Preliminary Acceptance Punchlist
El Paso County – Department of Public Works - Stormwater Section

Project Name:	Glen at Widefield F11
EDARP Filing Number(s):	ESQ2235
ESQCP Number:	SF204, CON2242
Attendees:	DPW SW: Natasha Grimaldo, Christina Prete, and Shannon Mustoe DPW Development Services: Brad Walters, David Parkerson, Amanda Rivera, and Spencer Pirzadeh Developer: Rudy Cross and Ryan Watson
Date of Walk-Thru:	04/10/2024
Walk-Thru Number:	1 st

Inflow 'H' Sedimentation Basin Detail

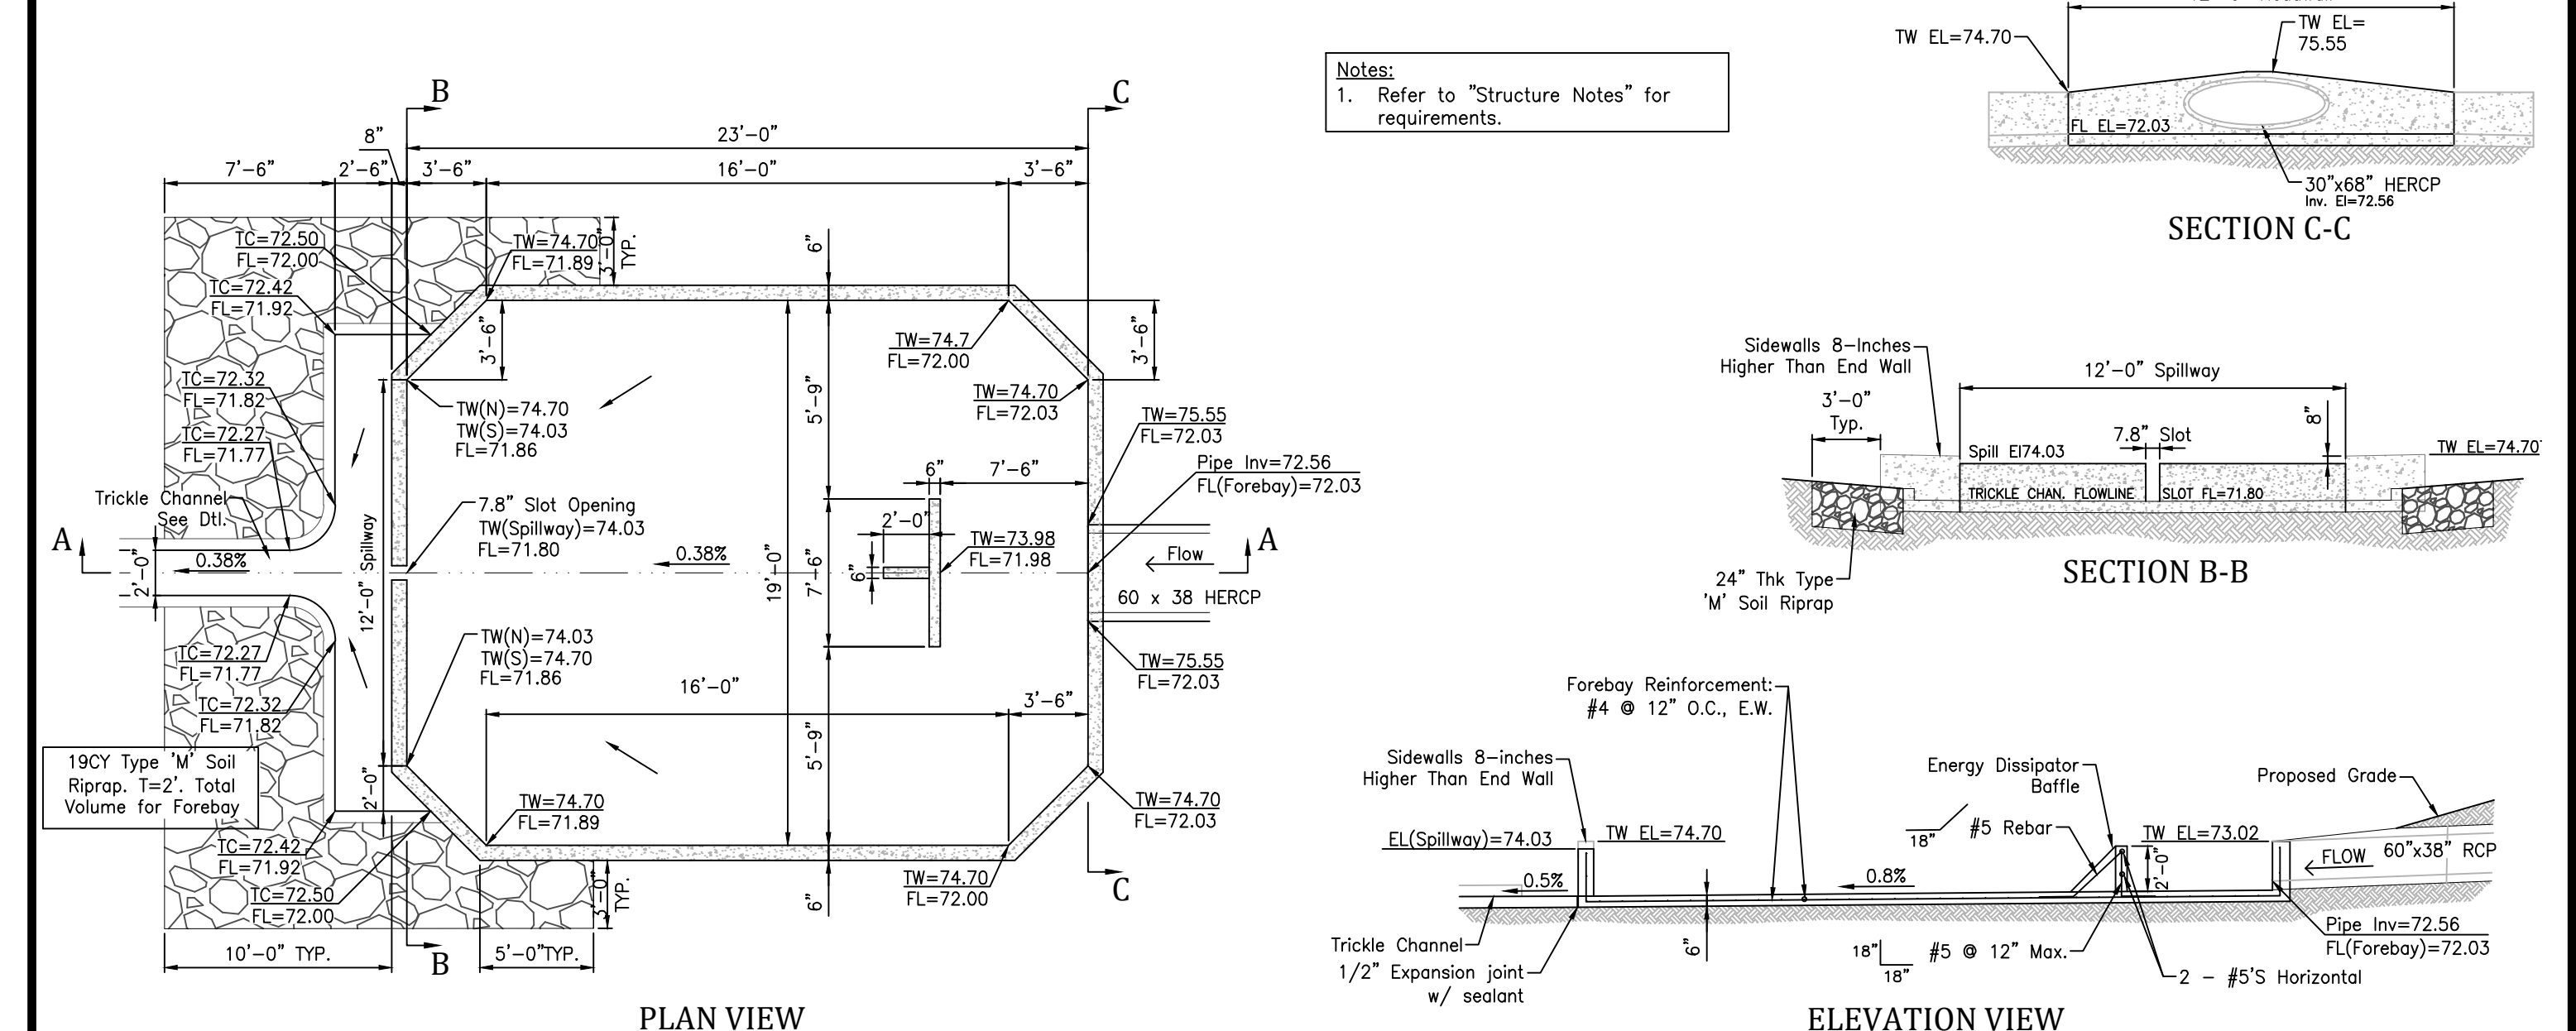
- Emergency Overflow: Confirm installation of soil riprap overflow on the east and west perimeter of Pennycress Dr. Existing spillway and rundown were to remain installed except where intercepted by Pennycress Dr. Reference Sheet 28 of the Construction Drawings. Reference Photos 8 and 10.
- Install Type M soil riprap with 3"-4" topsoil revegetated with seed mix. Current riprap does not consist of all Type M aggregate. Reference Sheet 28 of the Construction Drawings. Reference Photo 9.
- Pond Outfall: Confirm outfall elevation allows for positive drainage. Reference Photo 11.

- Pond Outlet Structure: Remove restrictor plate. Reference the Drainage Report. Reference Photo 14.
- Forebay J: Energy Dissipator Baffle was installed at 5'4" from the inflow pipe. Plans call for a distance of 7'6". Change structure to match approved plans or justify change in the As-builts/Drainage Report. Reference Sheet 28 of the Construction Drawings. Reference Photo 15.

- Forebay J: Inflow pipe measures 34"x53". Plans call for 19"x30". Change structure to match approved plans or justify change in the As-builts/Drainage Report. Reference Sheet 28 of the Construction Drawings. Reference Photo 16.

- Forebay J: Slot opening measures 10.5". Plans call for 7.8". Change structure to match approved plans or justify change in the As-builts/Drainage Report. Reference Sheet 28 of the Construction Drawings. Reference Photo 17.

- Forebay J: Install 16'x2'6" trickle channel at front of forebay per the approved plans. Reference Sheet 28 of the Construction Drawings. Reference Photo 18.

- Forebay J: Forebay measures 13'x17'2". Plans call for 23'x19'. Change structure to match approved plans or justify change in the As-builts/Drainage Report. Reference Sheet 28 of the Construction Drawings. Reference Photo 19.

- Pond: Trickle channel measures 1'. Plans call for 2'. Change structure to match approved plans or justify change in the As-builts/Drainage Report. Reference Sheet 28 of the Construction Drawings. Reference Photo 20.

- Forebay H: Fill in soil riprap to be free of voids and flush with grade. Reference Photos 21 and 22.
- Forebay H: Install 16'x2'6" trickle channel at front of forebay per the approved plans. Reference Sheet 28 of the Construction Drawings. Reference Photo 23.

- Forebay H: Spillway measures 17'11". Plans call for 12'. Change structure to match approved plans or justify change in the As-builts/Drainage Report. Reference Sheet 28 of the Construction Drawings. Reference Photo 24.

- Forebay H: Energy Dissipator Baffle was installed at 6'5" from the inflow pipe. Plans call for a distance of 7'6". Change structure to match approved plans or justify change in the As-builts/Drainage Report. Reference Sheet 28 of the Construction Drawings. Reference Photo 25.

- Forebay J: Forebay measures 18'5"x26'10". Plans call for 23'x19'. Change structure to match approved plans or justify change in the As-builts/Drainage Report. Reference Sheet 28 of the Construction Drawings. Reference Photo 27.

- Pond: Install 15' maintenance access road with 12" Class 6 road base per the approved plans. Reference Sheet 28 of the Construction Drawings. Reference Photos 28 and 29.

MODIFIED WQCV ORIFICE PLATE
SCALE: NTS

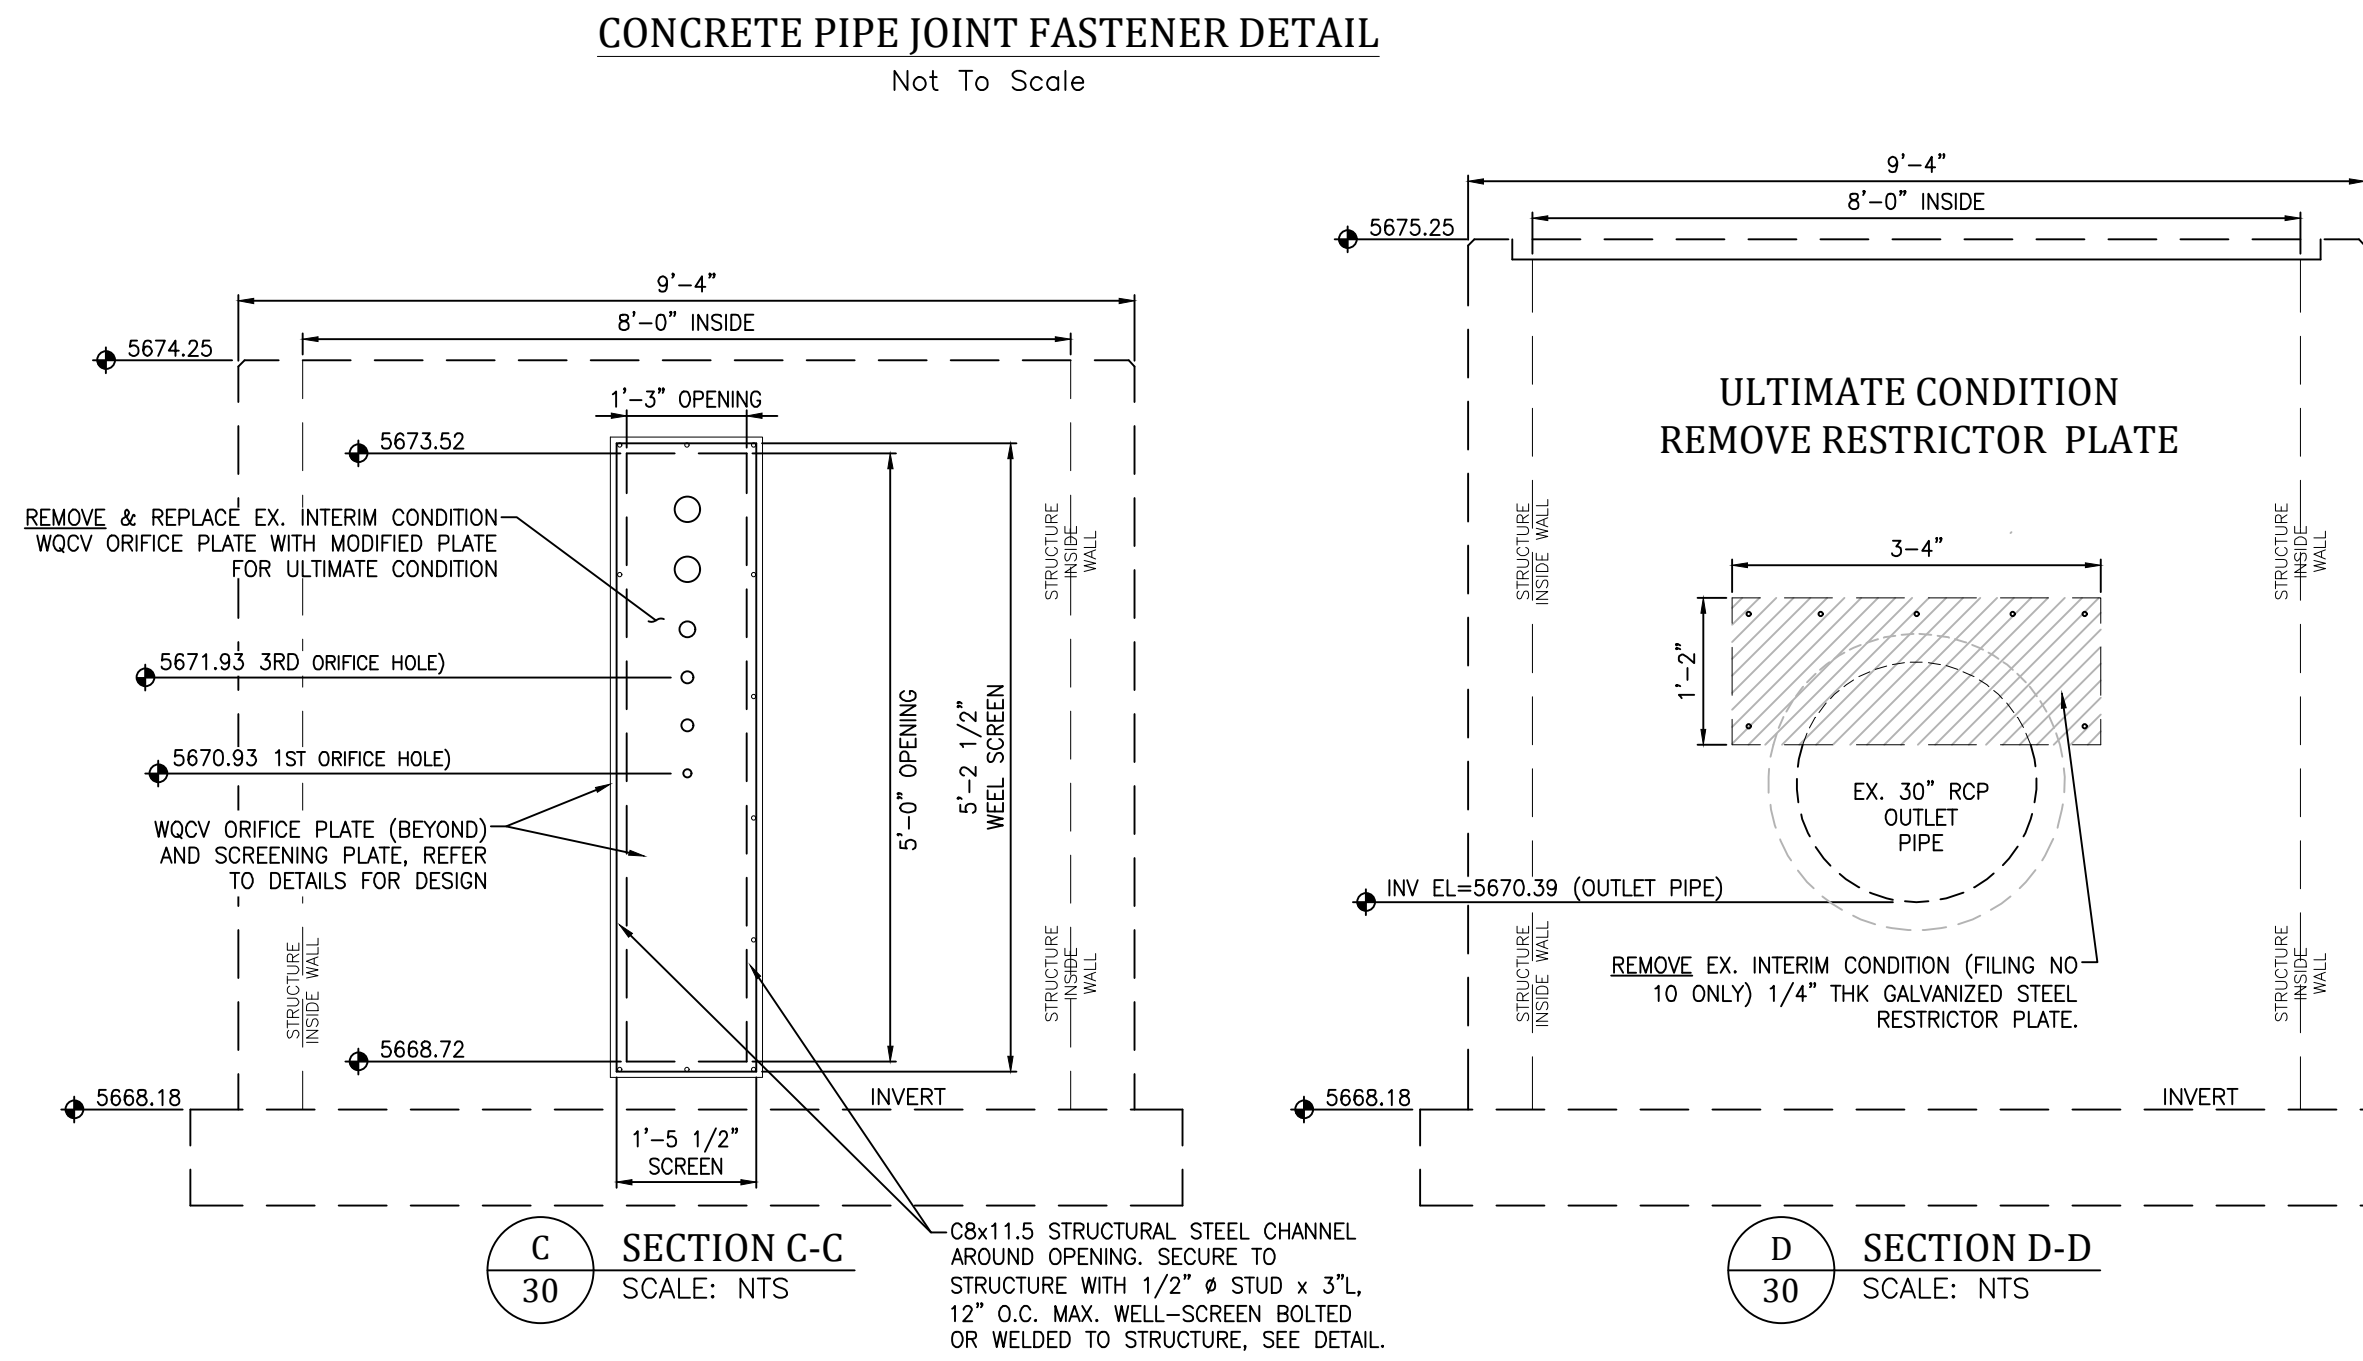
- Remove sediment, debris, and trash from riprap rundown. (Item is also noted on the F10 FA Punchlist). Reference Photo 12.
- Pond Outlet Structure: Install orifice plate with the proper sized holes. Reference Sheet 30 of the Construction Drawings. Reference Photo 13.
